Our ref: JA/CN/77526

14 December 2015

**PLANNING APPLICATION PP-04475191 AND 6/2015/1998/LB
COMET HOTEL, ST ALBANS ROAD WEST, HATFIELD, AL10 9RH
RESPONSE TO STATUTORY CONSULTATION**

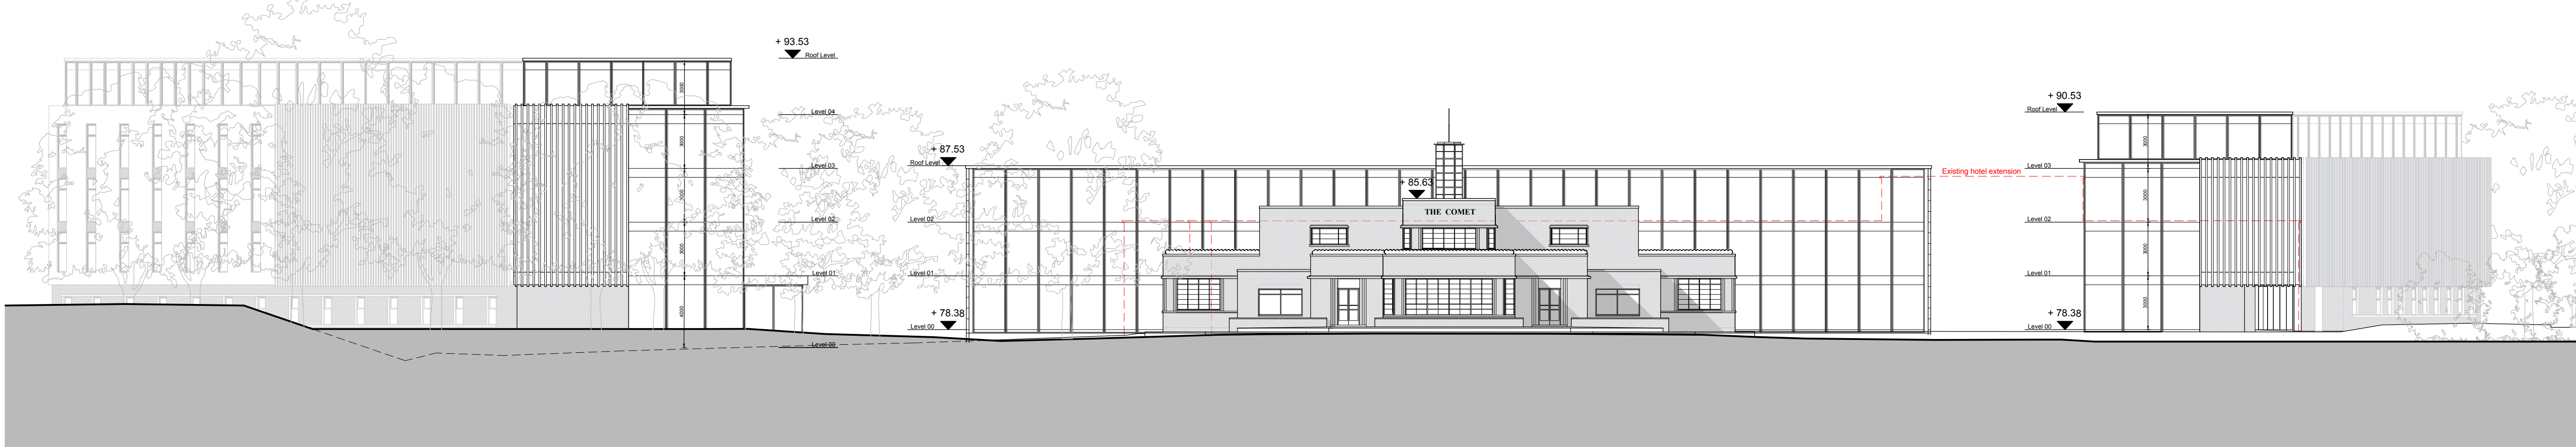
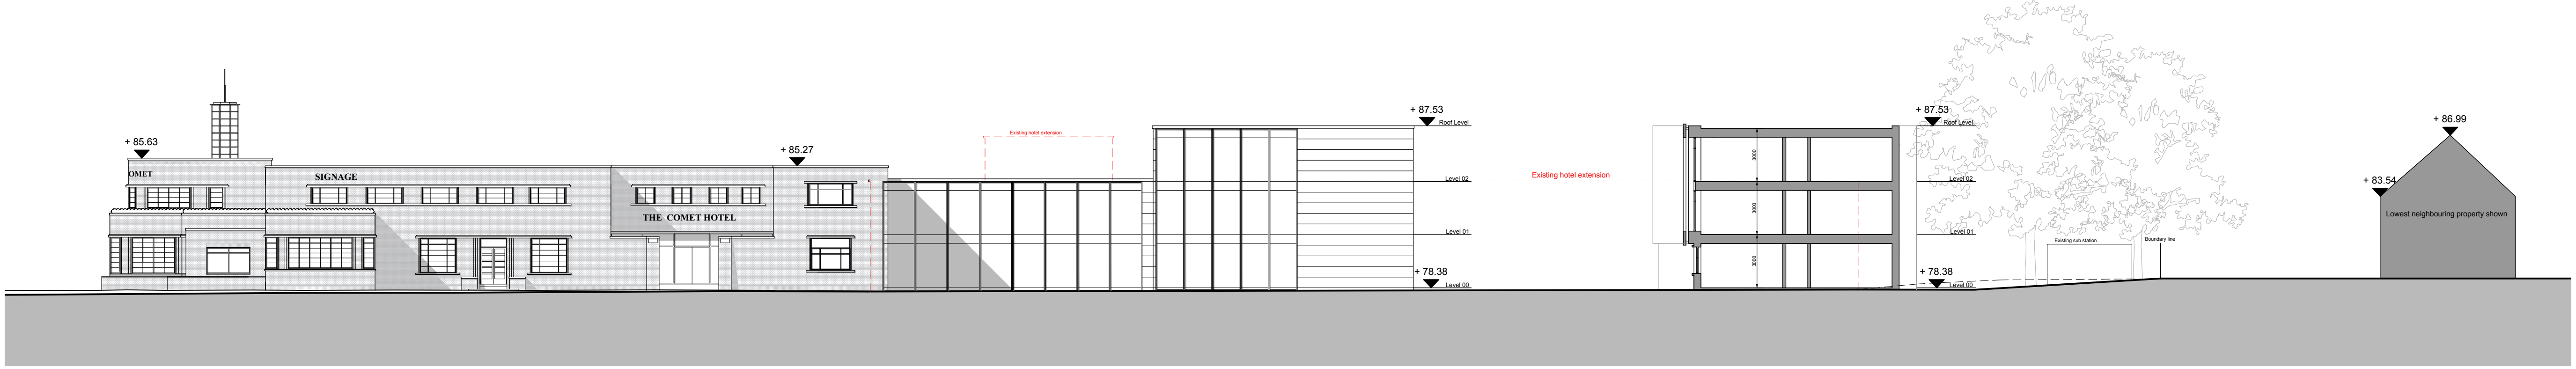
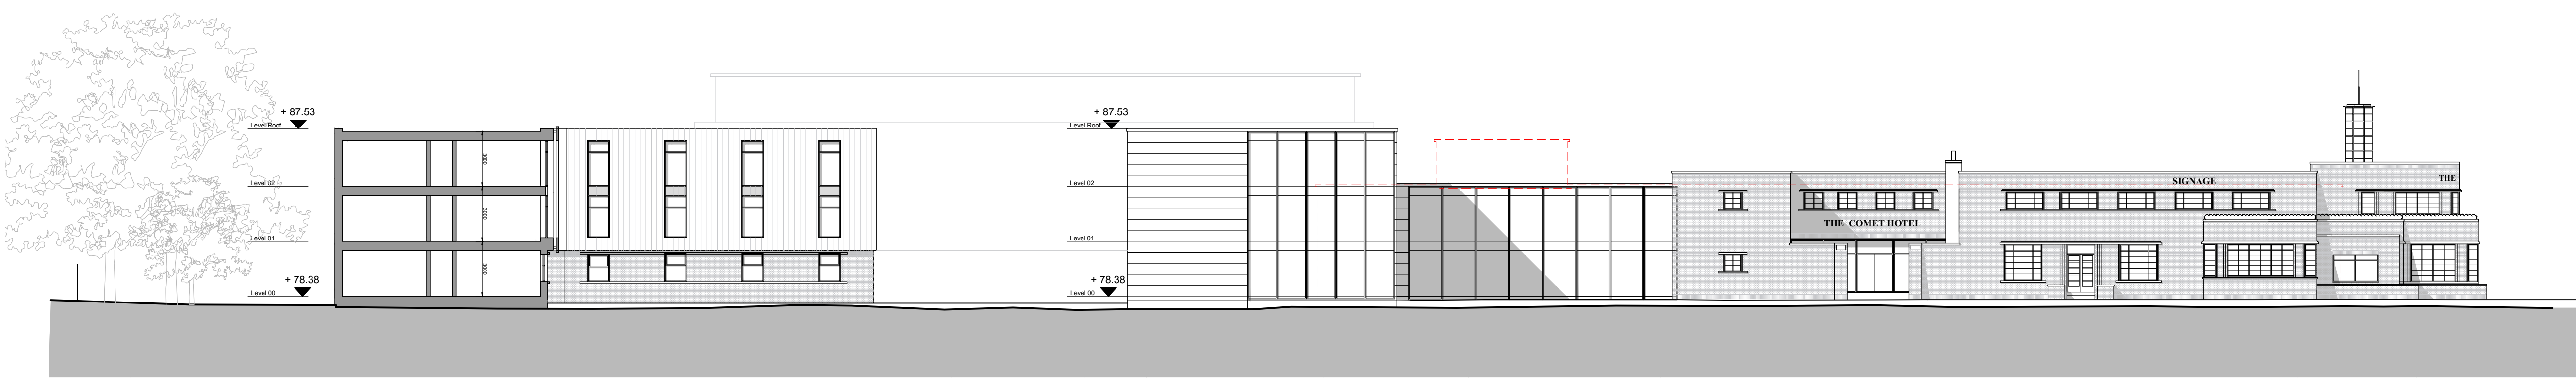
- The Conservation Officer (13 November 2015) stated that the difference between the existing hotel and the proposed hotel extension was 2.4m rather than the 1.9m stated in the planning application. We confirm that our figures are correct, as illustrated by the enclosed, annotated elevation plan. Our figures draw a comparison between the highest point of the hotel extension (87.53) and the highest point of the listed building (85.63), with the difference being 1.9m in height. This is the most consistent comparison, comparing the highest points of the existing building with the highest point of the proposed extension;
